S19-0011 LIVERPOOL HEALTH AND ACADEMIC PRECINCT_LETTER MSCP CLOUSTON_CL
21.8.20

LIVERPOOL HOSPITAL MULTI STOREY CAR PARK (SSD 10388) - RESPONSE TO AGENCY SUBMISSIONS

CLOUSTON Associates are the Landscape Architects for the LHAP (SSD 10388) project. The following responses address key comments received from Liverpool City Council.

PROJECT NO.	DRAWING NO.	ISSUE
21807	A-SSDA-MSCP-05	06
STATUS	FOR REVIEW

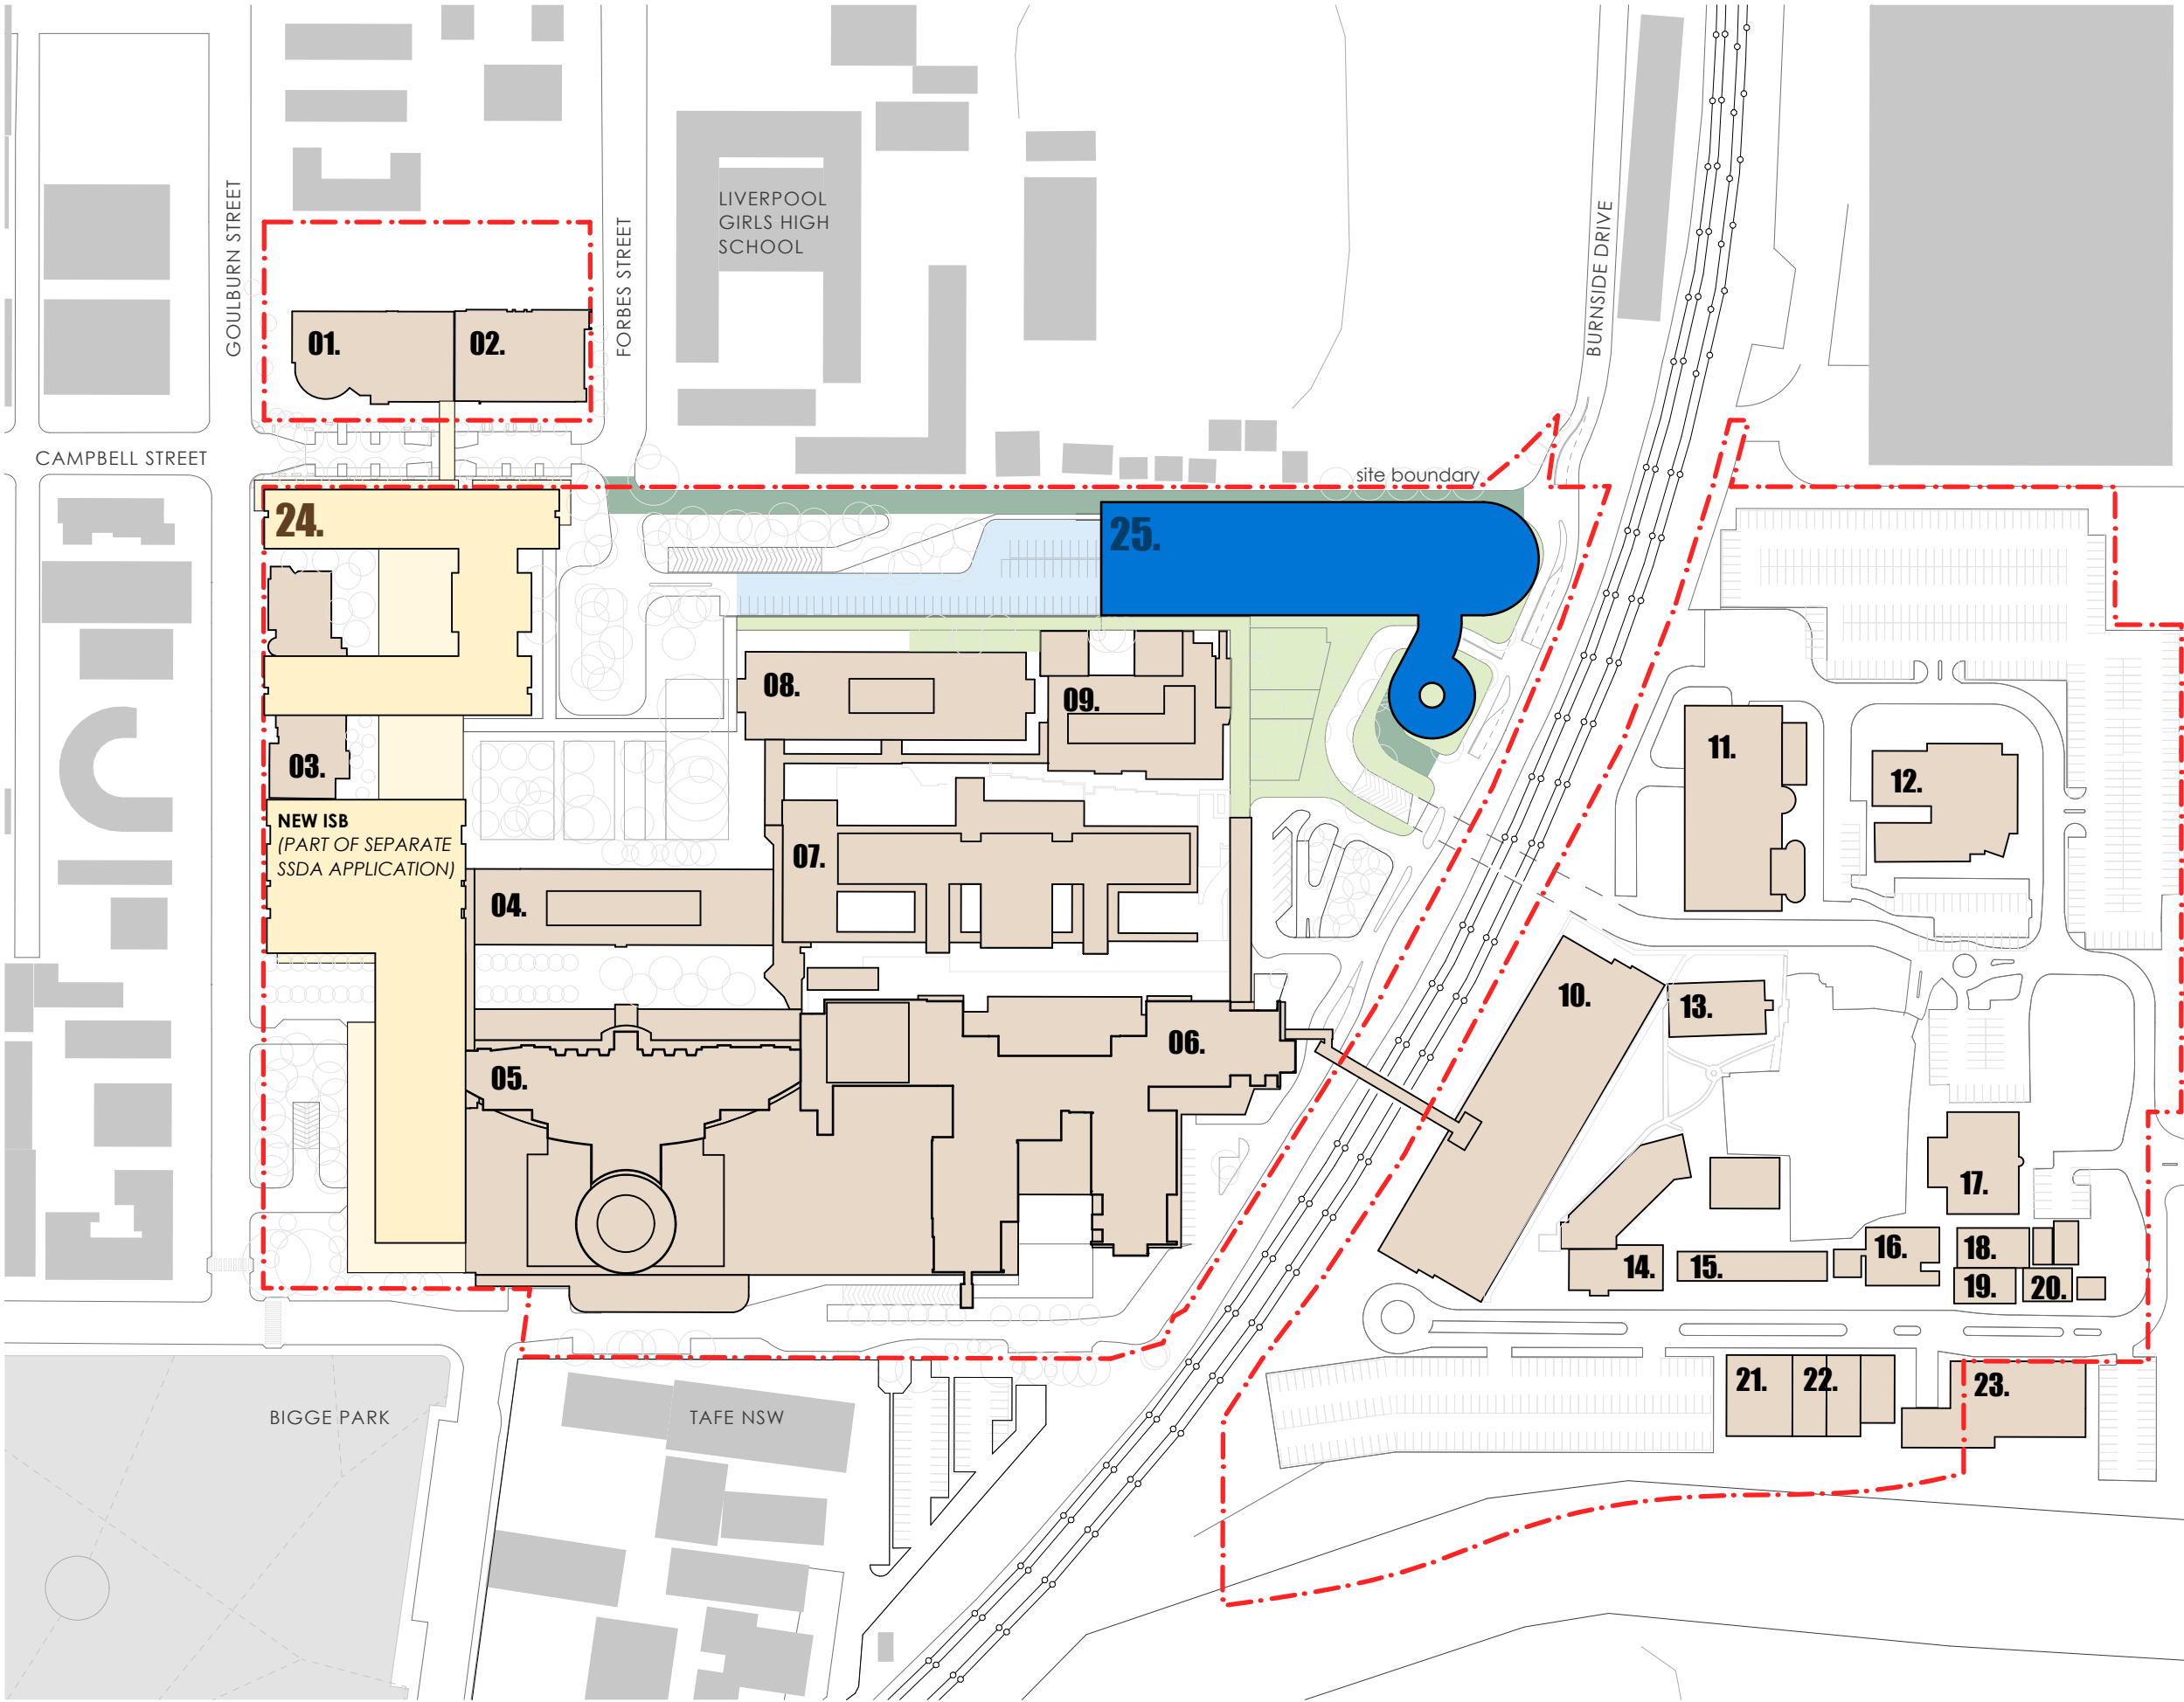
Replace some of the parking bays (i.e. within the proposed at-grade carpark), with garden beds that include mature trees, to provide shade and mitigate the impacts of urban heat within the site.

CLOUSTON Response: For the seven level Multi Storey Car Park additional trees have been added into the at-grade car park, providing additional canopy cover, habitat and heat island mitigation. The tree planting utilises structural soil systems to provide trees with the best opportunity to reach full mature size. This focus on soil conditions ensures that a small number of trees can maximise positive impacts.
